SUBDIVISION PLAN

PROJECT: MIXED USE DEVELOPMENT OF LAND OWNED BY J.B. BROWN & SONS COMMERCIAL AND MAPLE STREETS PORTLAND, MAINE
RECORD OWNER: J.B. BROWN & SONS P.O. BOX 207 PORTLAND, ME 04112

S01
SHEET: 1 OF 2

SHEET: 1 OF 2

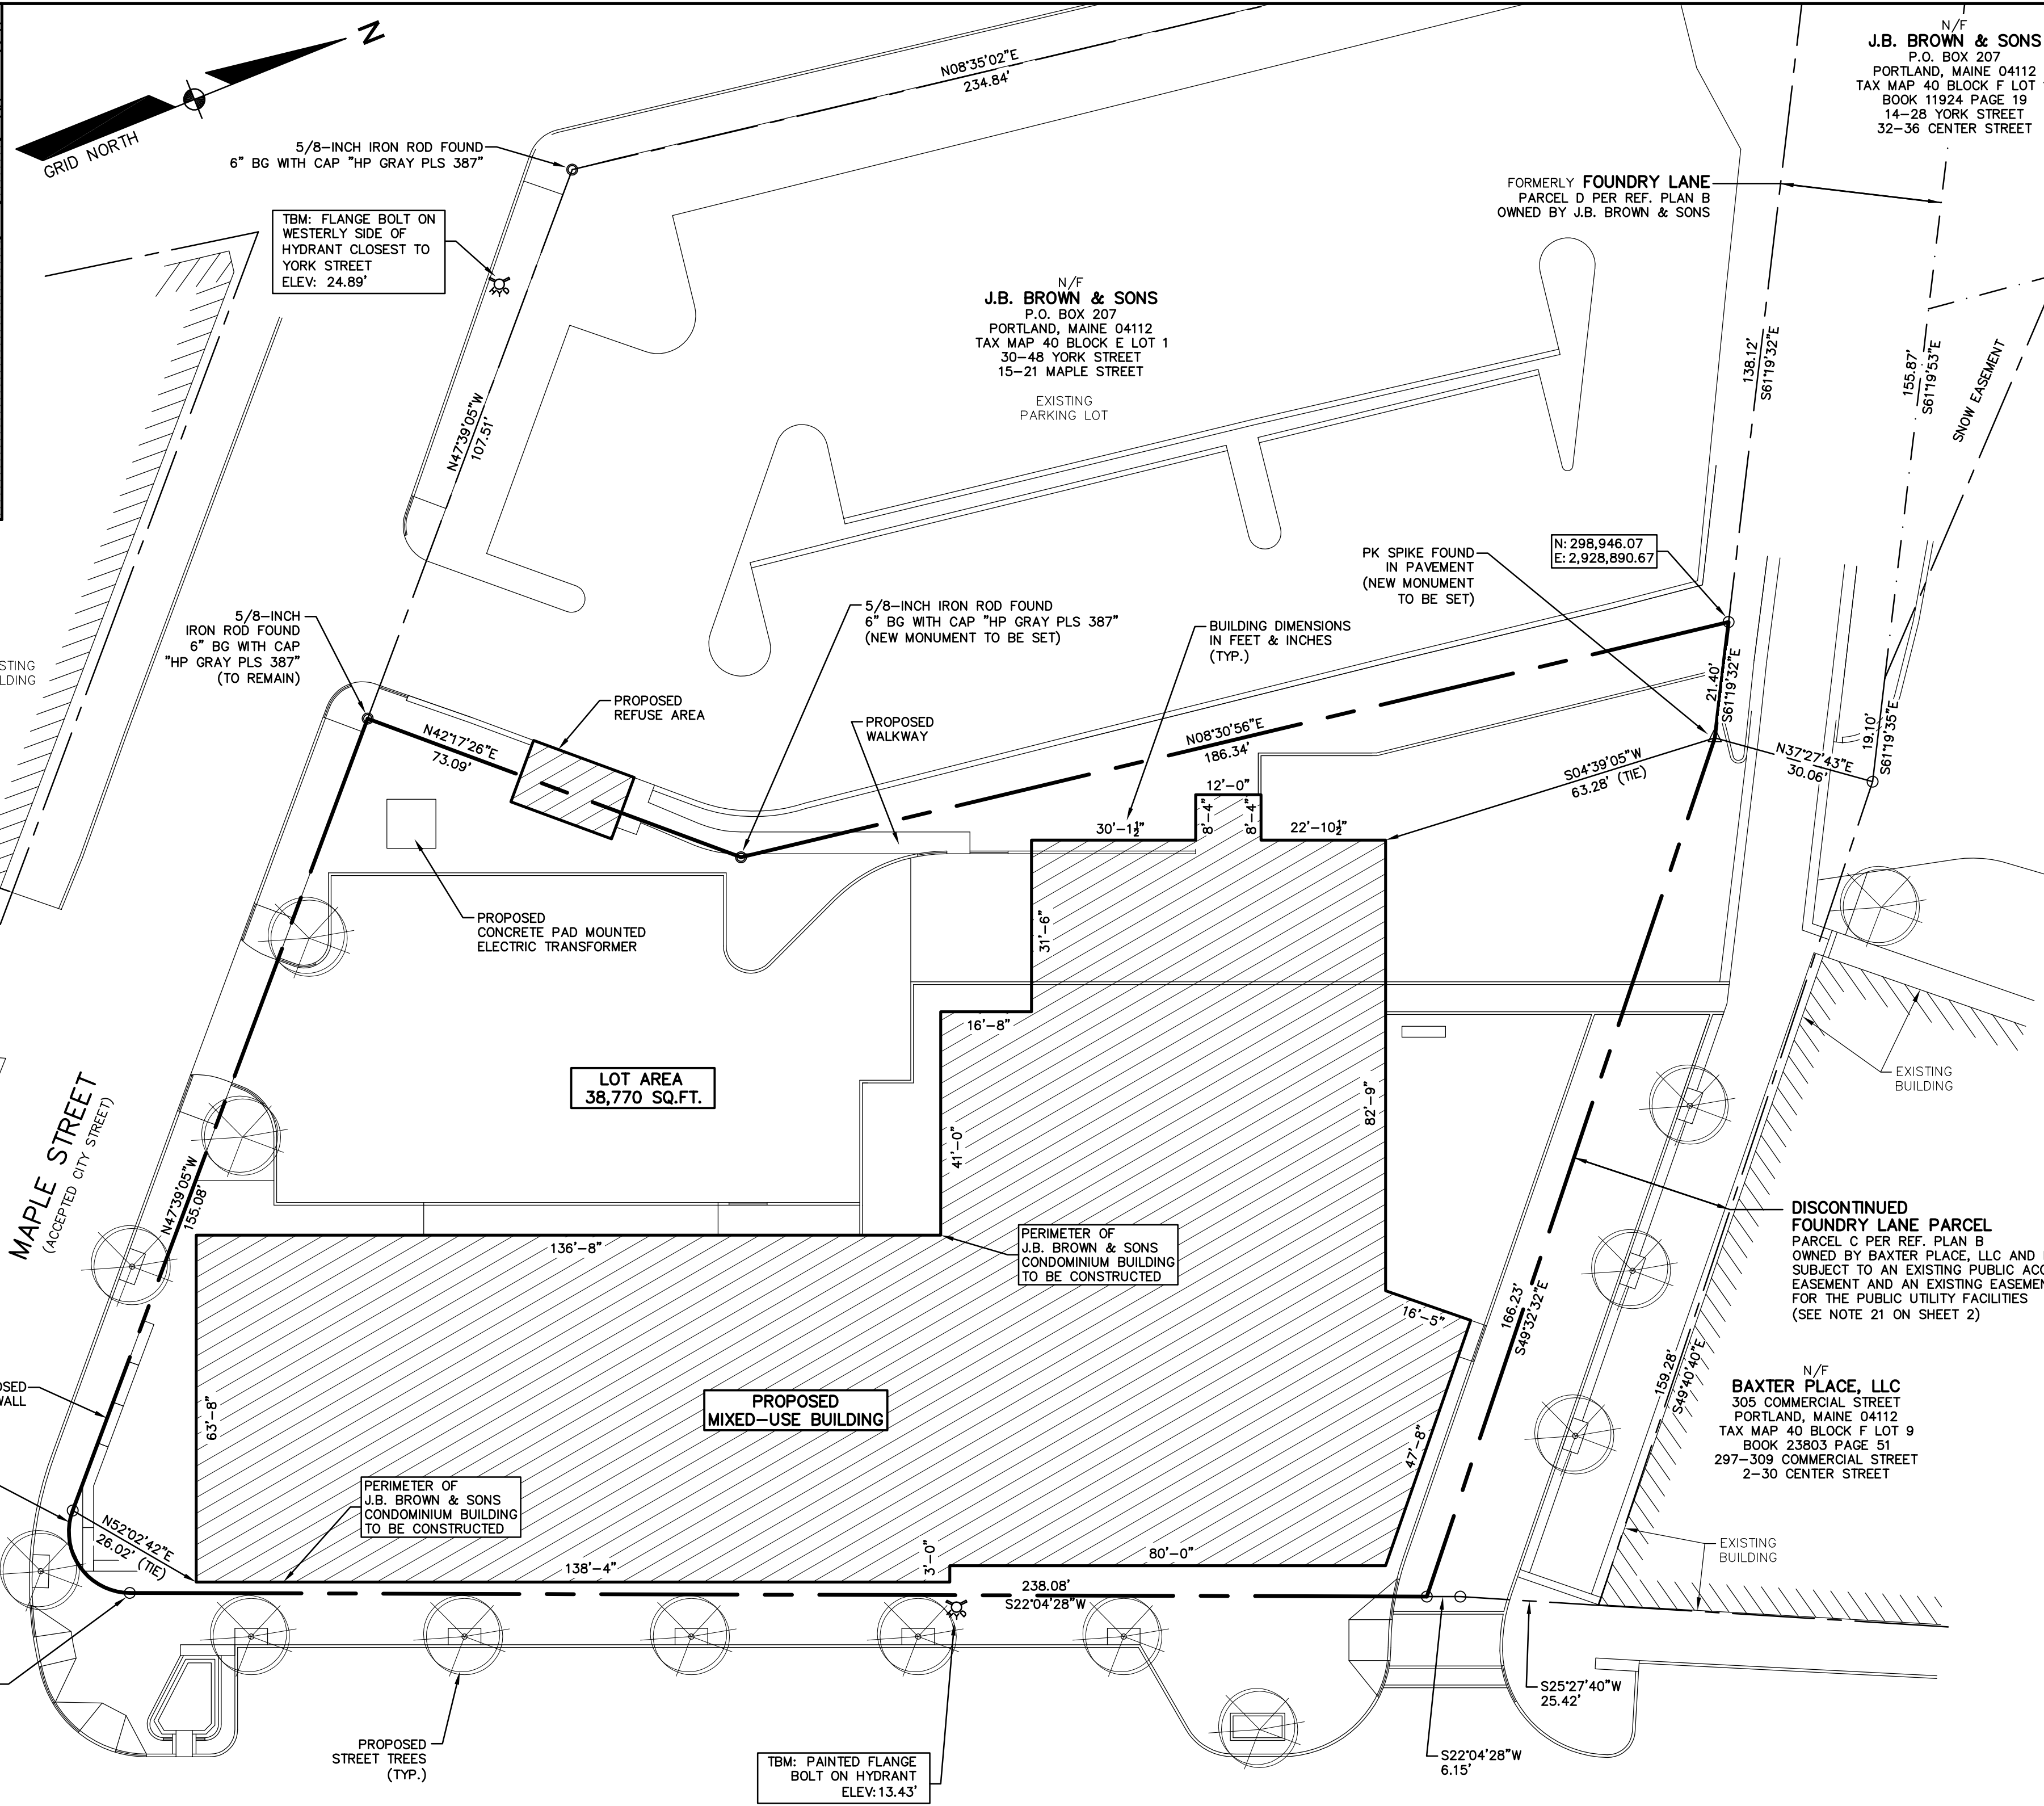
is the refuse area encroaching on the proposed walkway?

monuments are only set 3.00' into accepted streets

granite monument to be set on 3.00' offset line

20.00' along R/W from property corner

Will this require a license from the City?
Who will be responsible for maintenance?
Will there be a maintenance agreement?
